MR DAVID TIMSO  
LOGOS PROPERTY  
167 MACQUARIE STREET  
SYDNEY NSW 2000

**RE: LENORE DRIVE, ERSKINE PARK: LOT 62 DP1097134 NUMBERS 133 - 135.  
PROPOSED DEVELOPMENT**

The above property is affected by the easement for the 132kV-transmission line, feeder 219 and 939. Consequently, the property is subject to some restrictions within the easement area.

ACCESS TRACK SECTION  
1: 100 scale

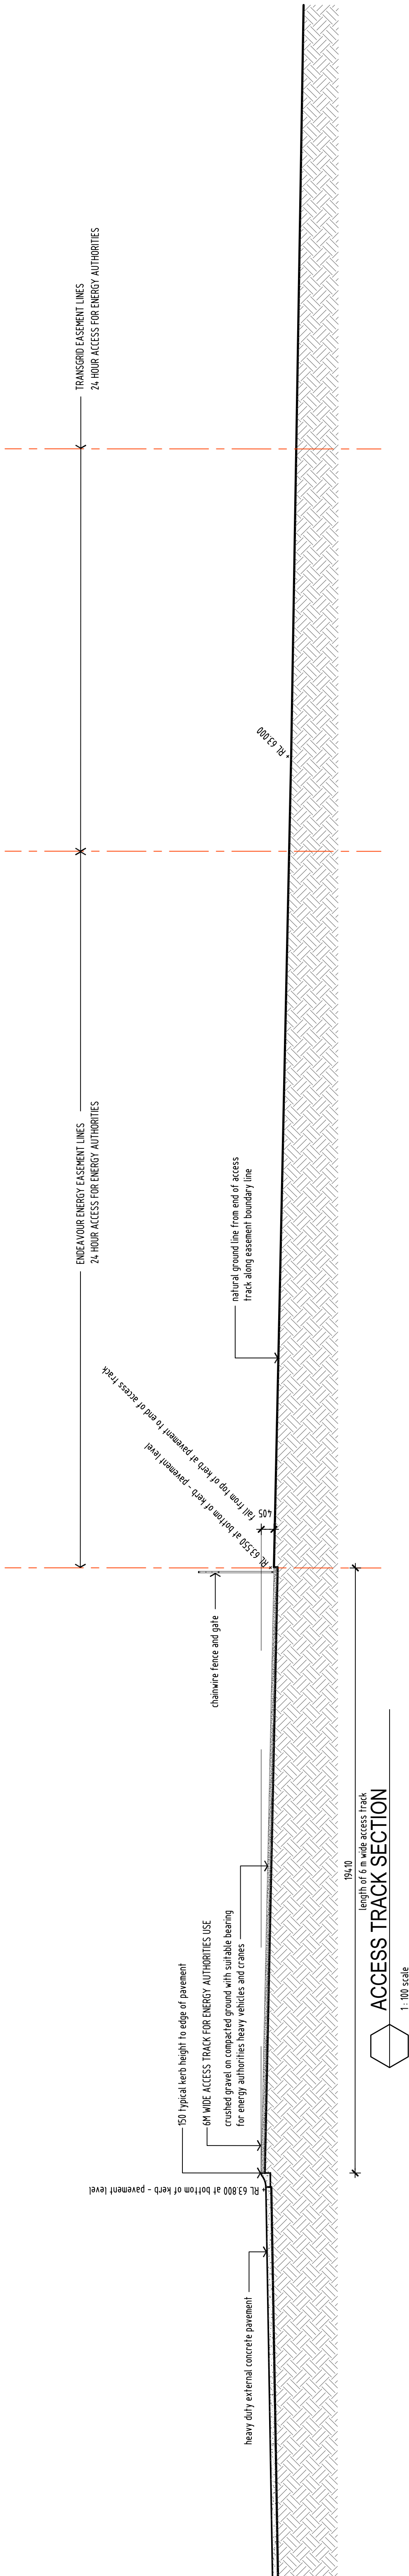
- A 4 metre wide track is to be provided within the easement, parallel to the conductors and a minimum of 5 metre out from the conductors. This track is to be a continuation of the track already approve on the adjoin site, lot 7.

- The finished surface level of this access to be flat, finished with a suitable material and able to withstand the weight of Endeavour Energies heaviest and largest vehicles and the track is to be maintenance free.

- Armco railing is to be installed at the top of the batter both around the structures and along the access track.
- Excavation work within the easement is to be undertaken either by hand or a vehicle of no more than 4 metres at maximum height and extension of reach (Vehicles, plant or equipment having a height when fully extended that exceeds 4 metres shall not be brought onto an easement area without the prior written approval of Endeavour Energy)
